# CITY OF PORTLAND

# BUILDING PERMIT

Job ID: 2011-12-2851-ALTR

has permission to Expand a Rear Dormer From 5 Feet to 10 Feet Wide (Single Family Residence).

ANSWERS TO QUESTIONS IN E-MAIL FOR S1 PROJECT

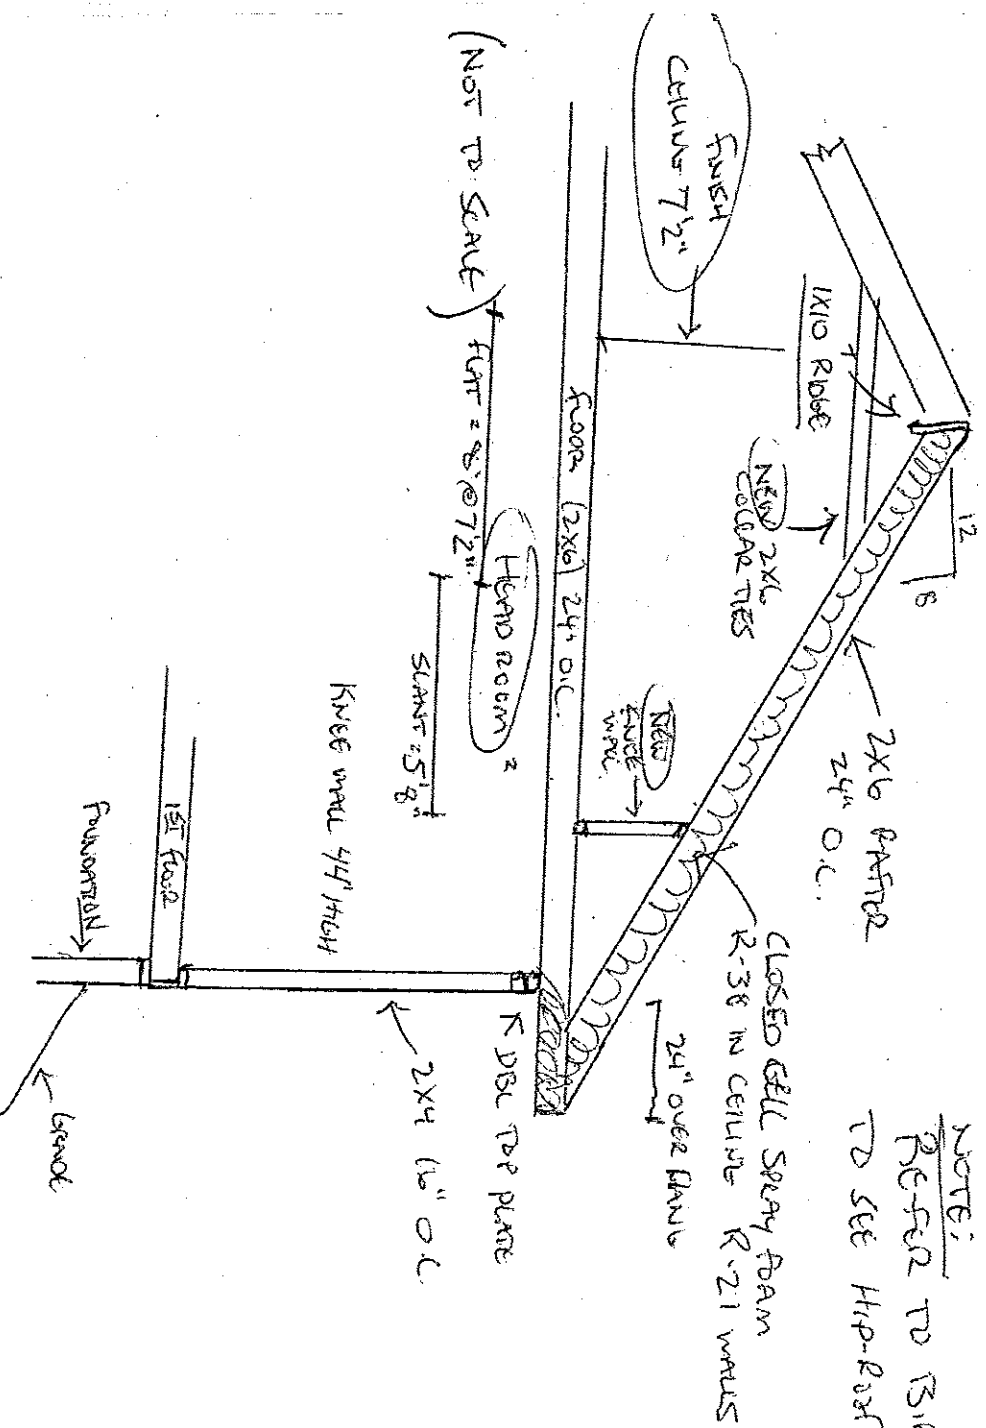
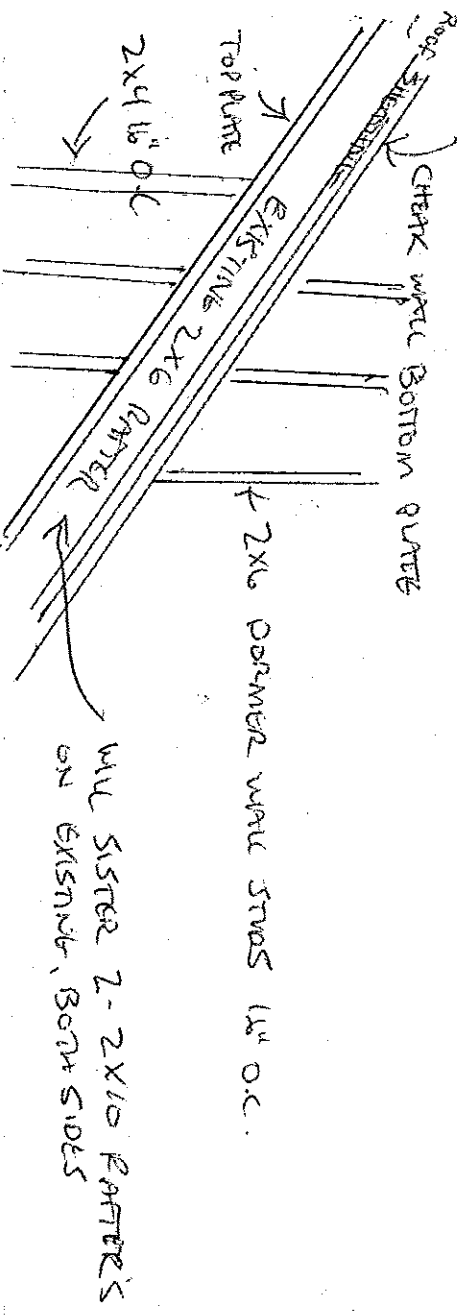
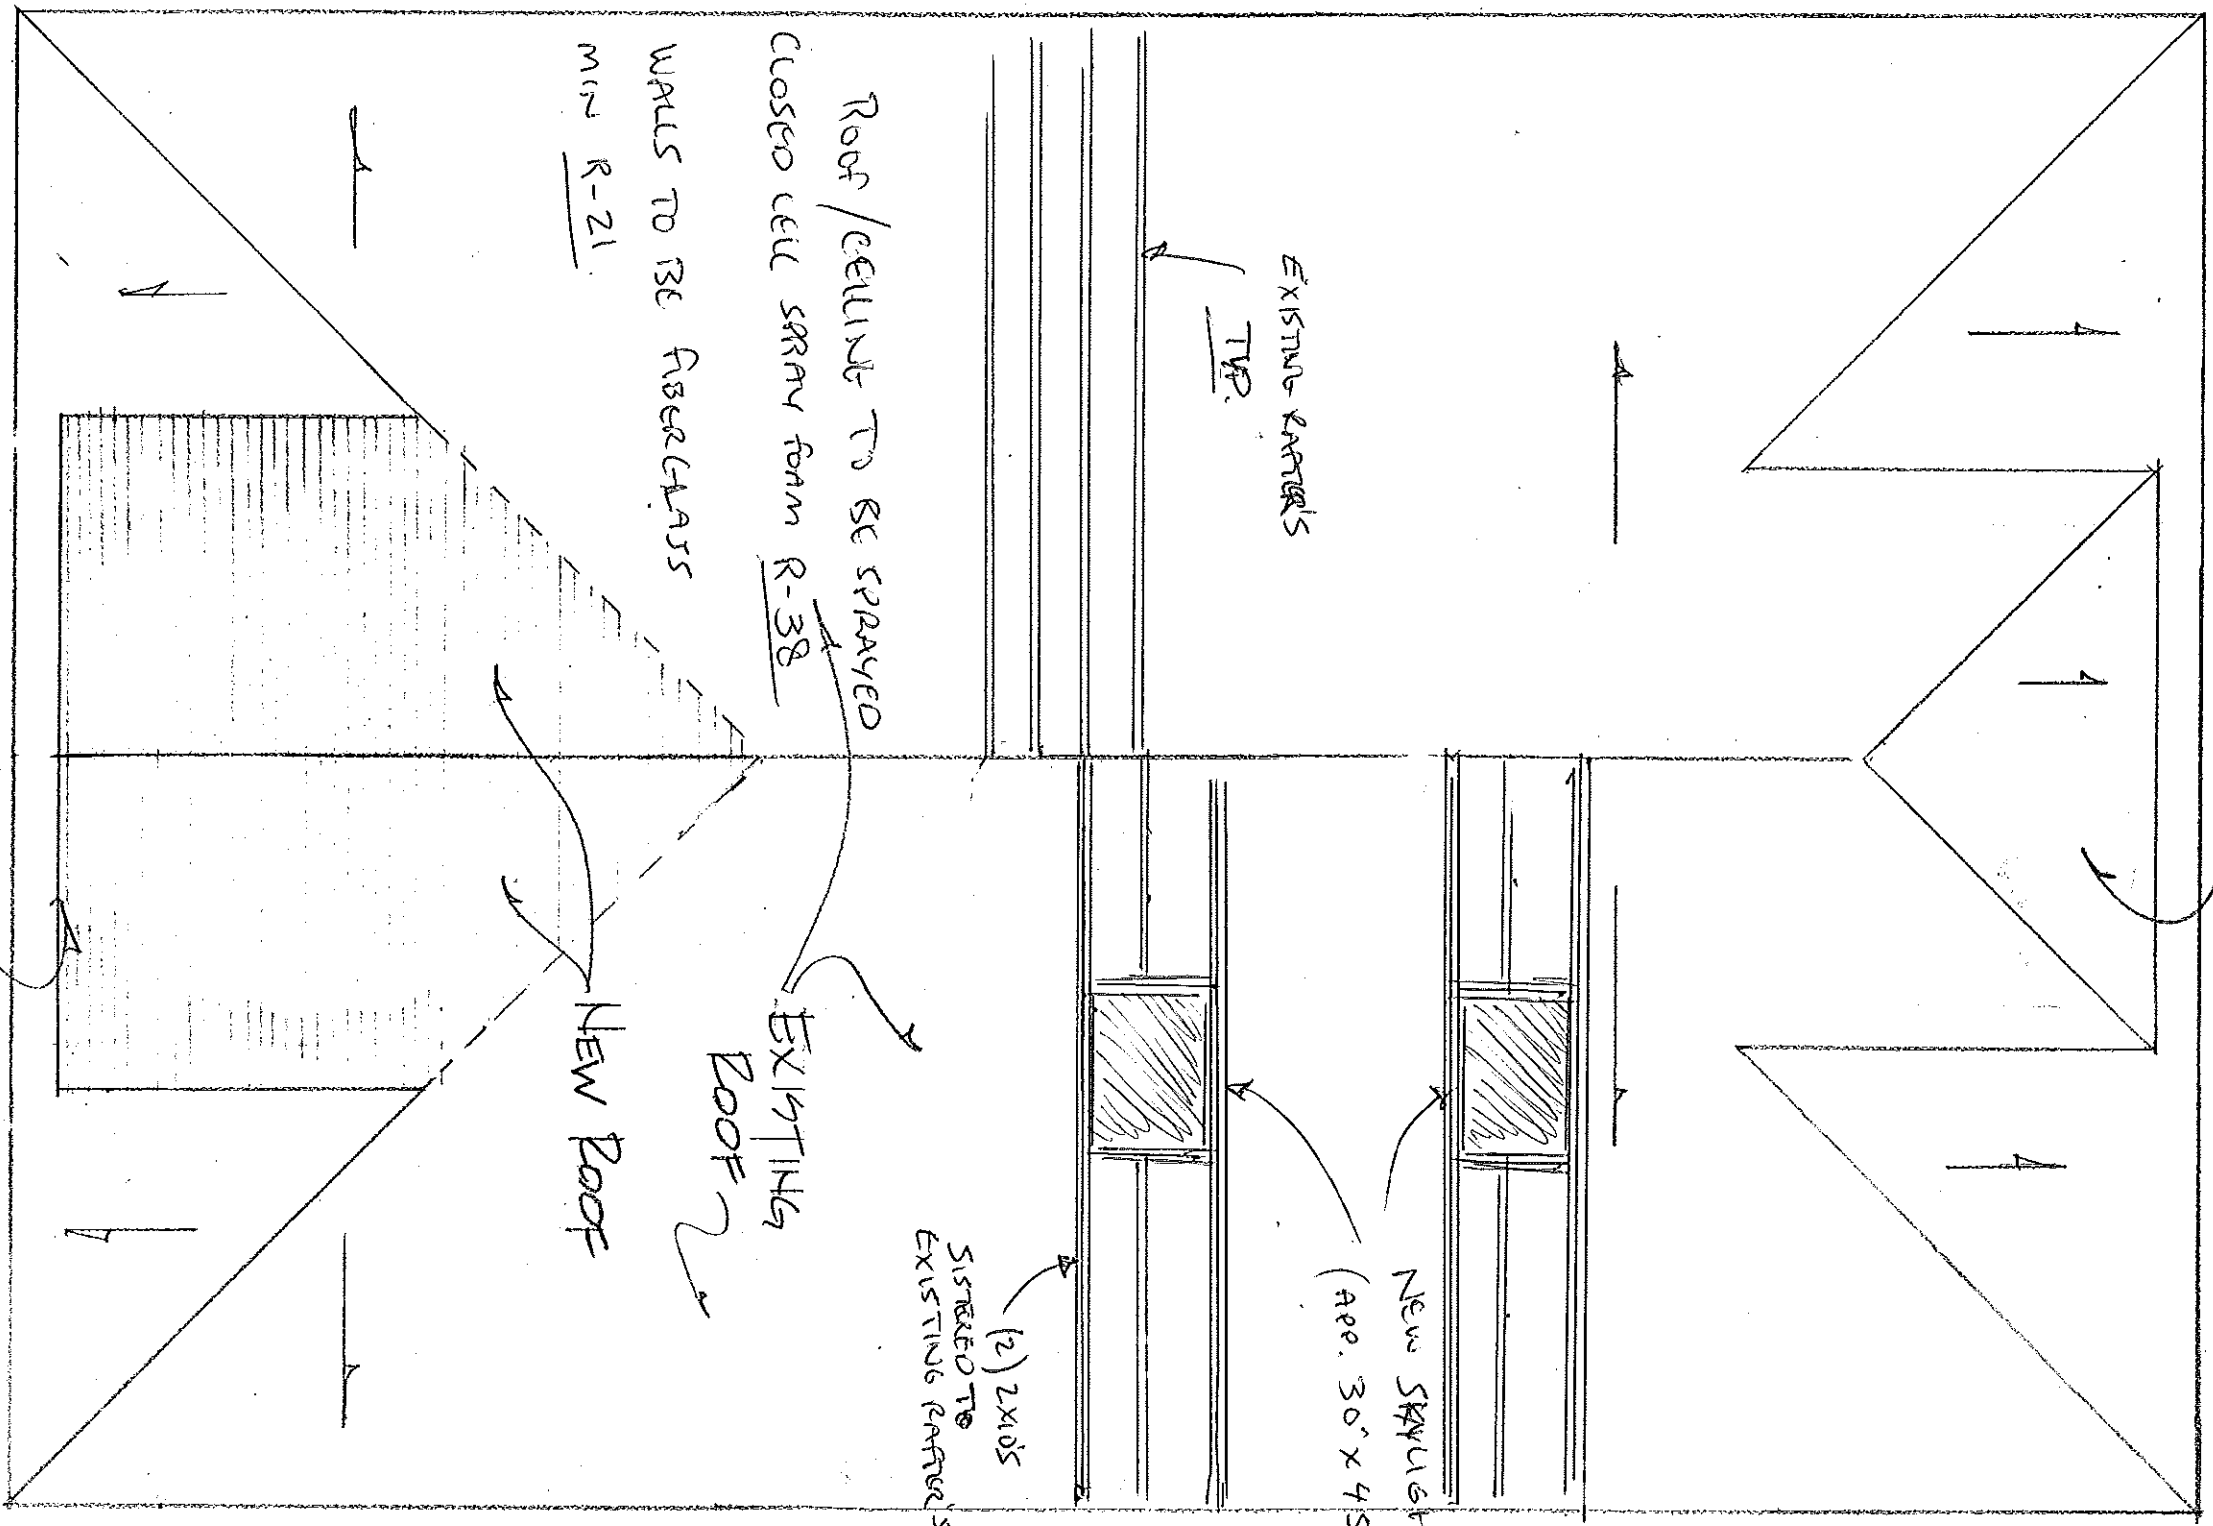
- We need a roof framing detail (Cross-Section From Structural Ridge to Foundation)
- A detail on the Dormer meeting the existing roof
- What will the finishing headroom/ fixture clearance be from floor to ceiling?
- What are you using from Wall/ Roof Sheathing?
- Insulation?

Roof Plan 1/4" = 1'-0"

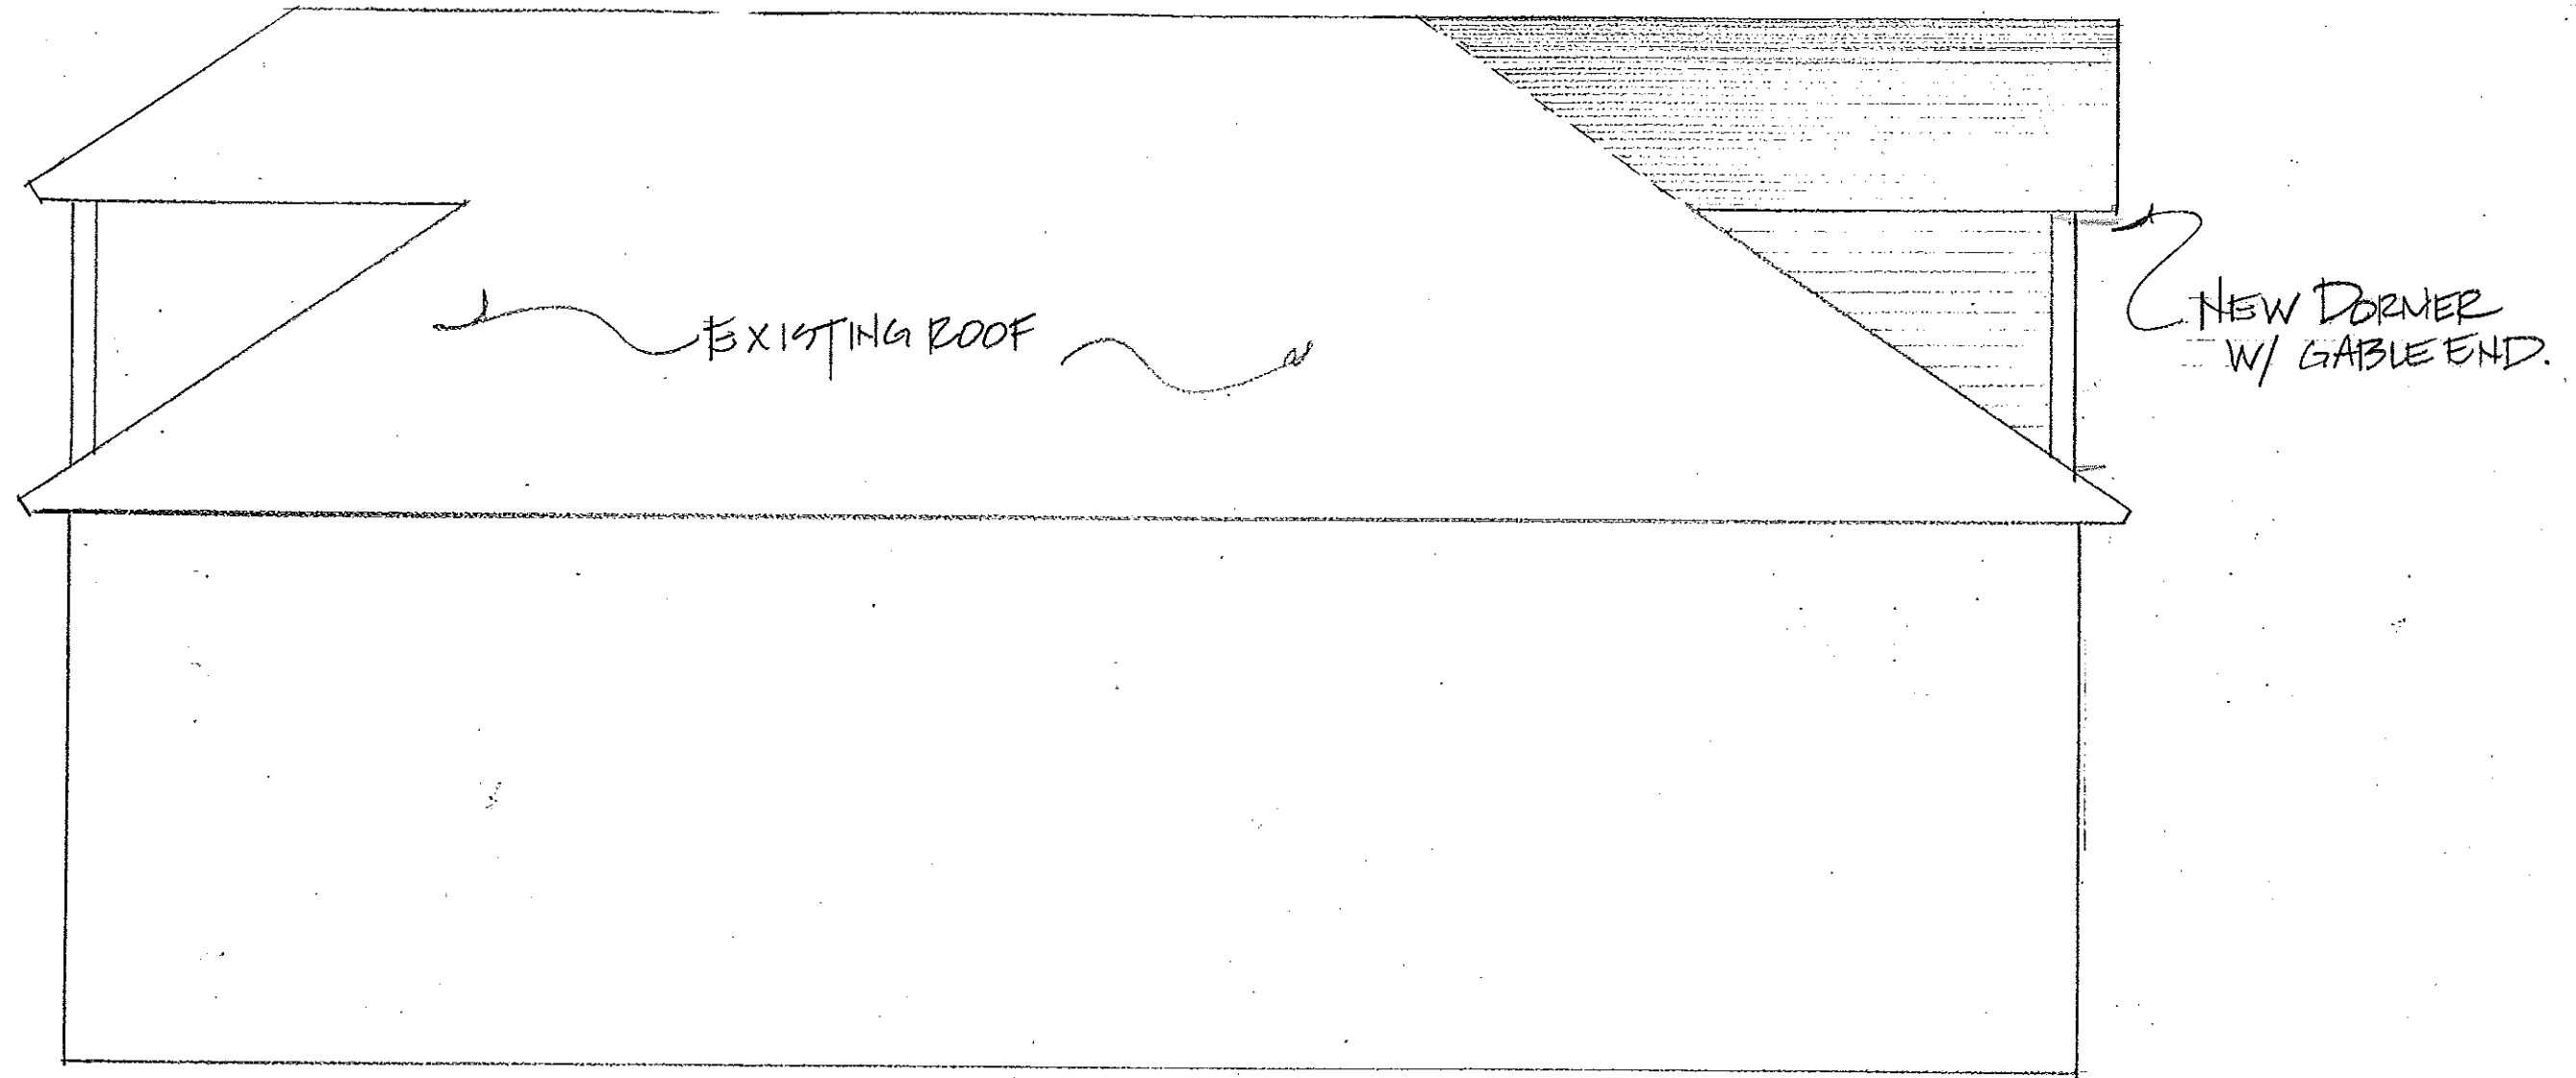
1. Separate permits are required for any electrical: plumbing, sprinkler, fire alarm, HVAC systems, commercial hood exhaust systems and fuel tanks. Separate plans may need to be submitted for approval as a part of this process.
2. Roof Rafter framing and Connection shall comply with Section R802.3 & R802.3.1 of MUBEC.
3. **A code compliant emergency escape shall be provided in the habitable attic area.** Window sills in locations more than 72 inches from finished grade shall be a minimum of 24 inches (no higher than 44 inches) above the finished floor of the room, or in compliance with Section R612.4.2 Operation for emergency escape.
4. A Carbon Monoxide (CO) alarms shall be installed in each area within or giving access to bedrooms. That detection must be powered by the electrical service (plug-in or hardwired) in the building and battery.
